SUBMISSION

Rye Park Wind Farm Modification 1 SSD-6693 – Mod 1

1. I write as the owner of “Wattle Vale”, to object to proposed Modification 1 to Development Consent SSD-6693 for the Rye Park Wind Farm. My objections are on the grounds of visual impacts, noise impacts and biodiversity impacts as set out below. This submission has been prepared with the benefit of advice of senior and junior counsel specialising in environmental and planning law.

Location of Turbines to be Removed

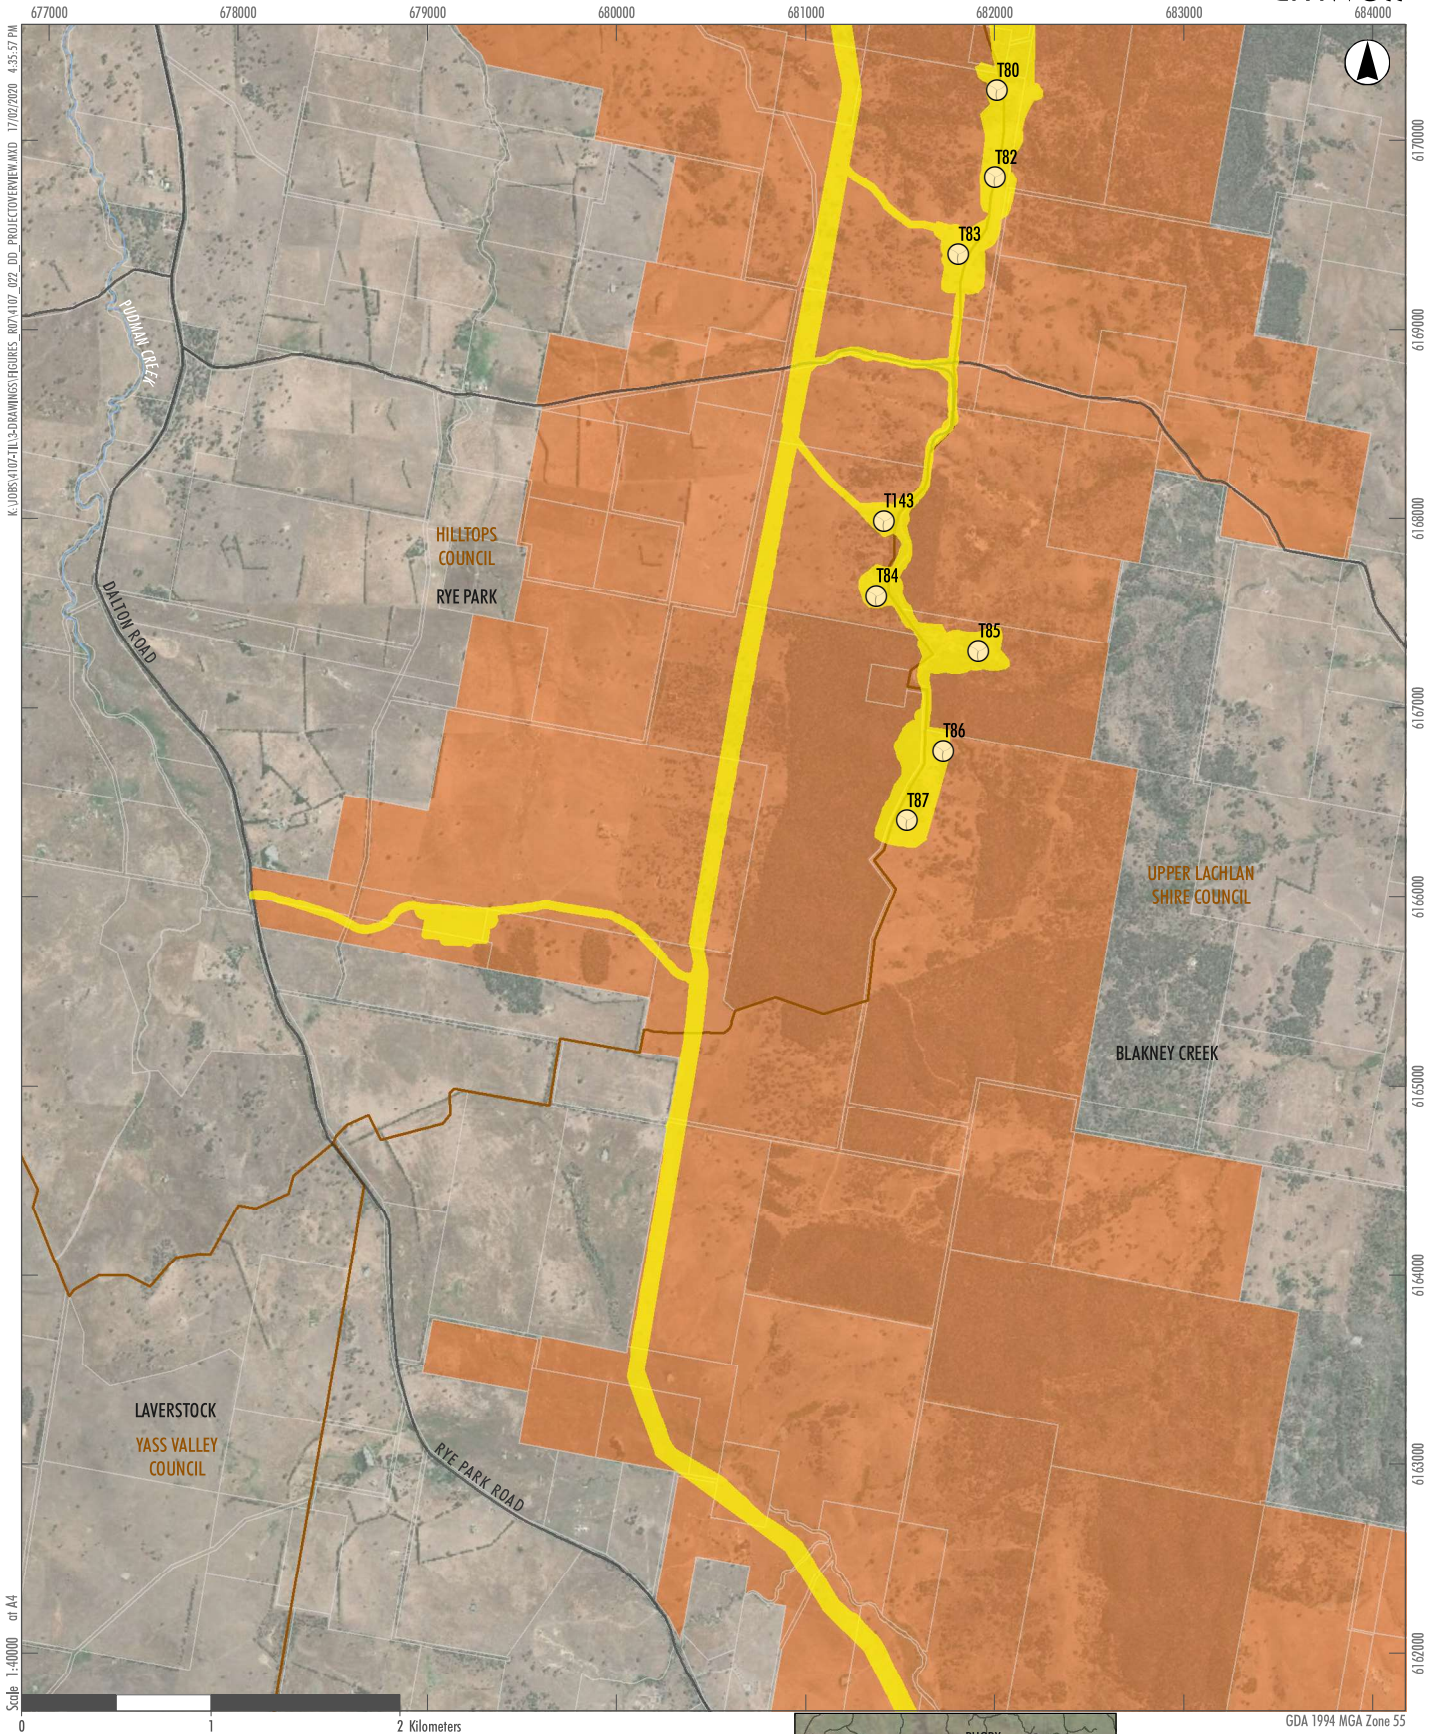
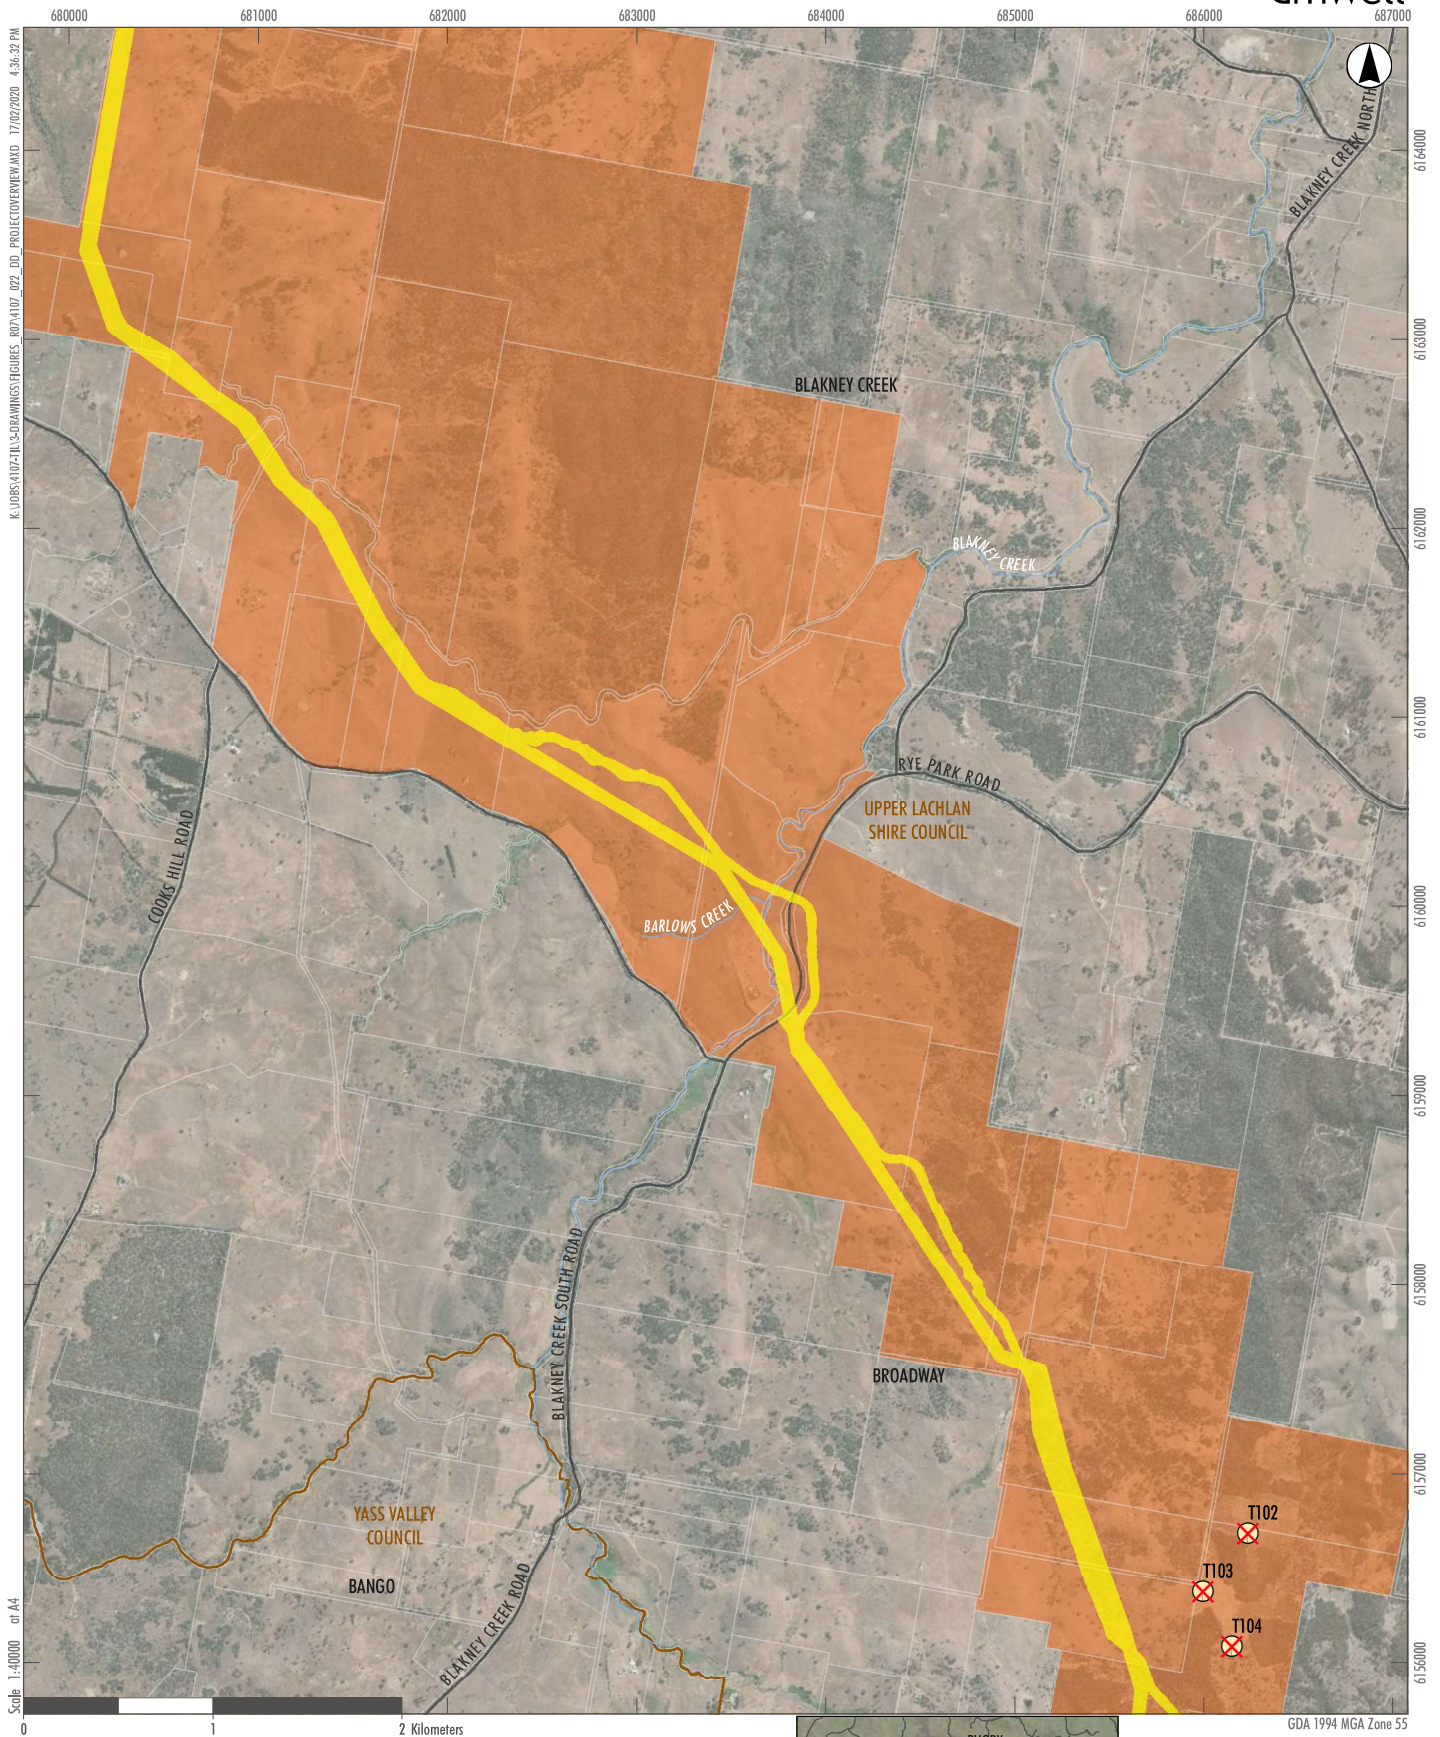
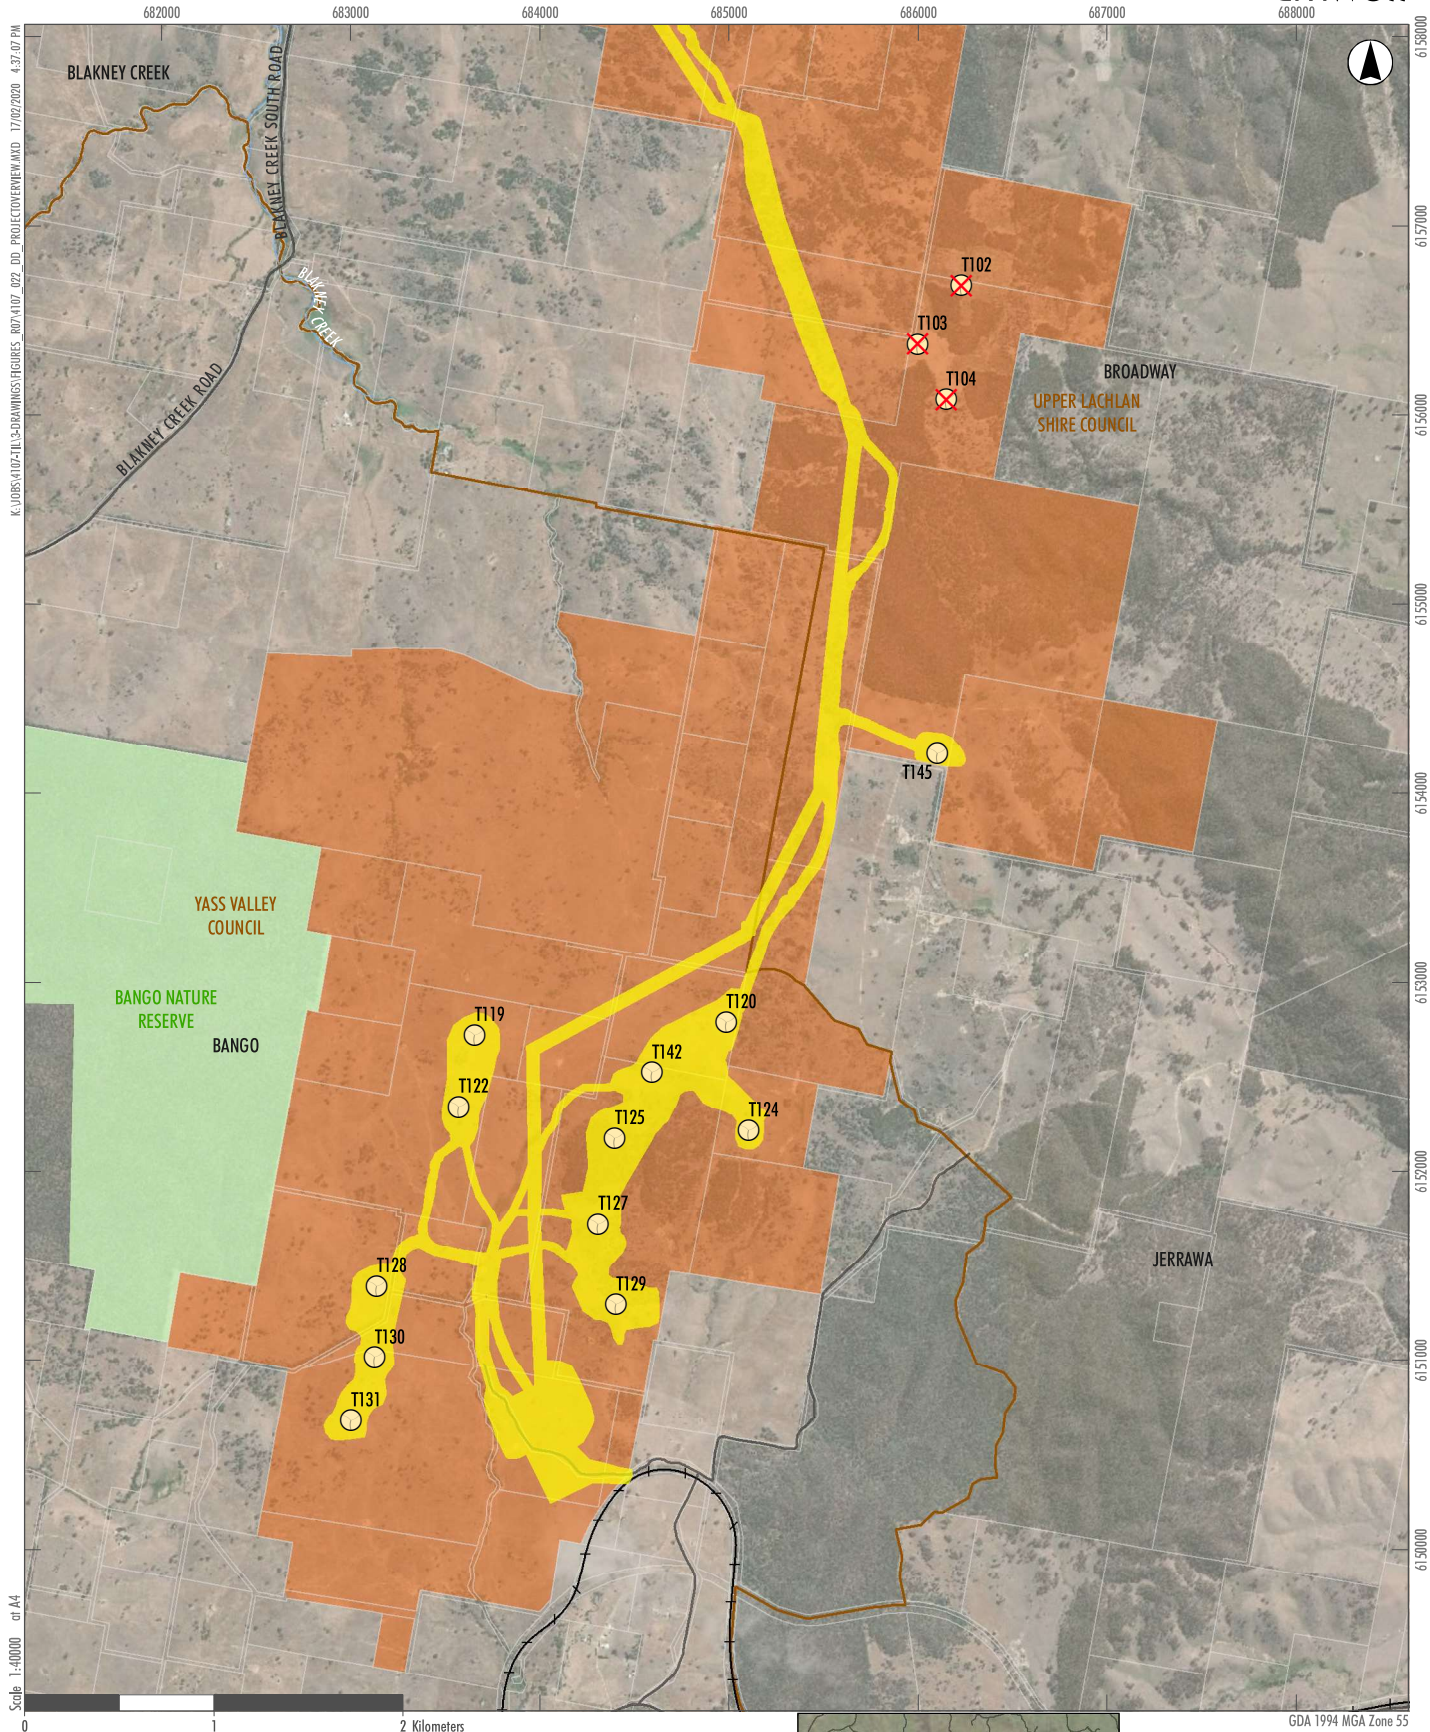
4. The VIA at Fig 1 and 2 contains a plan of the turbines which are to be deleted. However, this actually shows the difference between the Response to Submissions proposal and the modified proposal, rather than between the approved and modified proposal. Thus, it gives the impression of more turbines being deleted as part of the modification application than is actually the case.

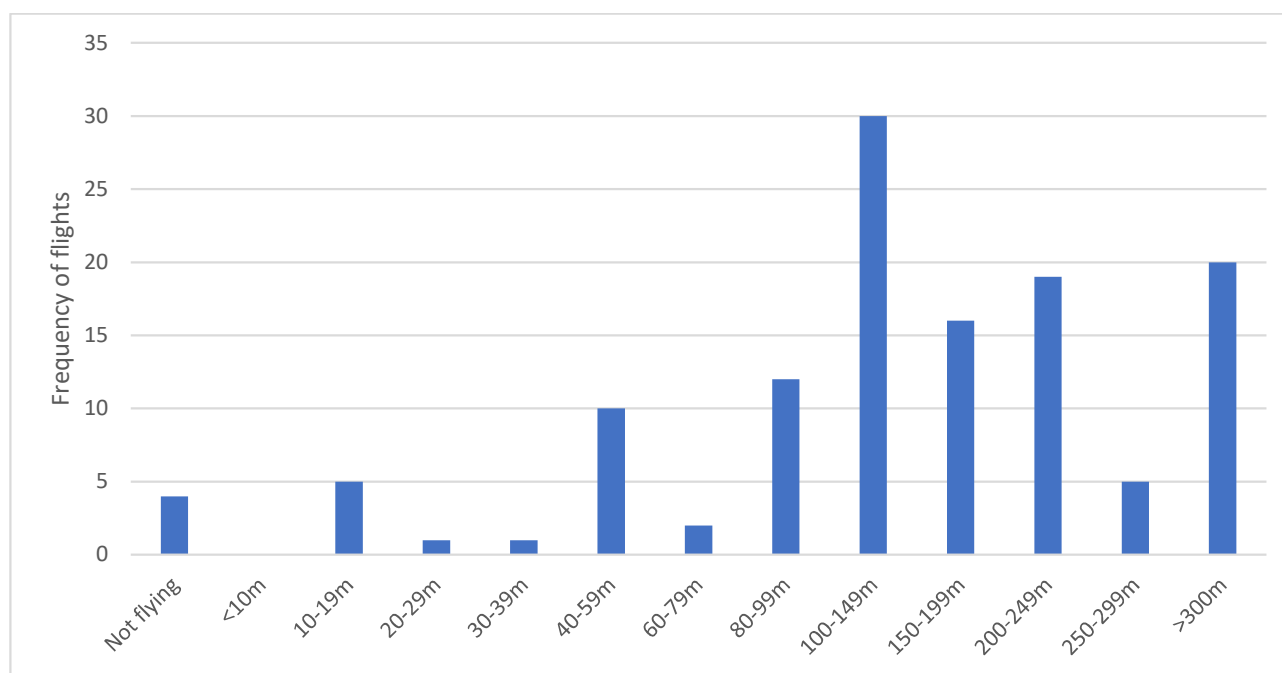
35. The BBA also fails to consider the possible impacts of the increased rotor size on the Wedge-tailed Eagle. This species, although not threatened, nevertheless forms an iconic part of the natural ecosystem. As a large, high-flying raptor, it will be impacted by the full extent of the proposed 49% increase in total rotor swept area.
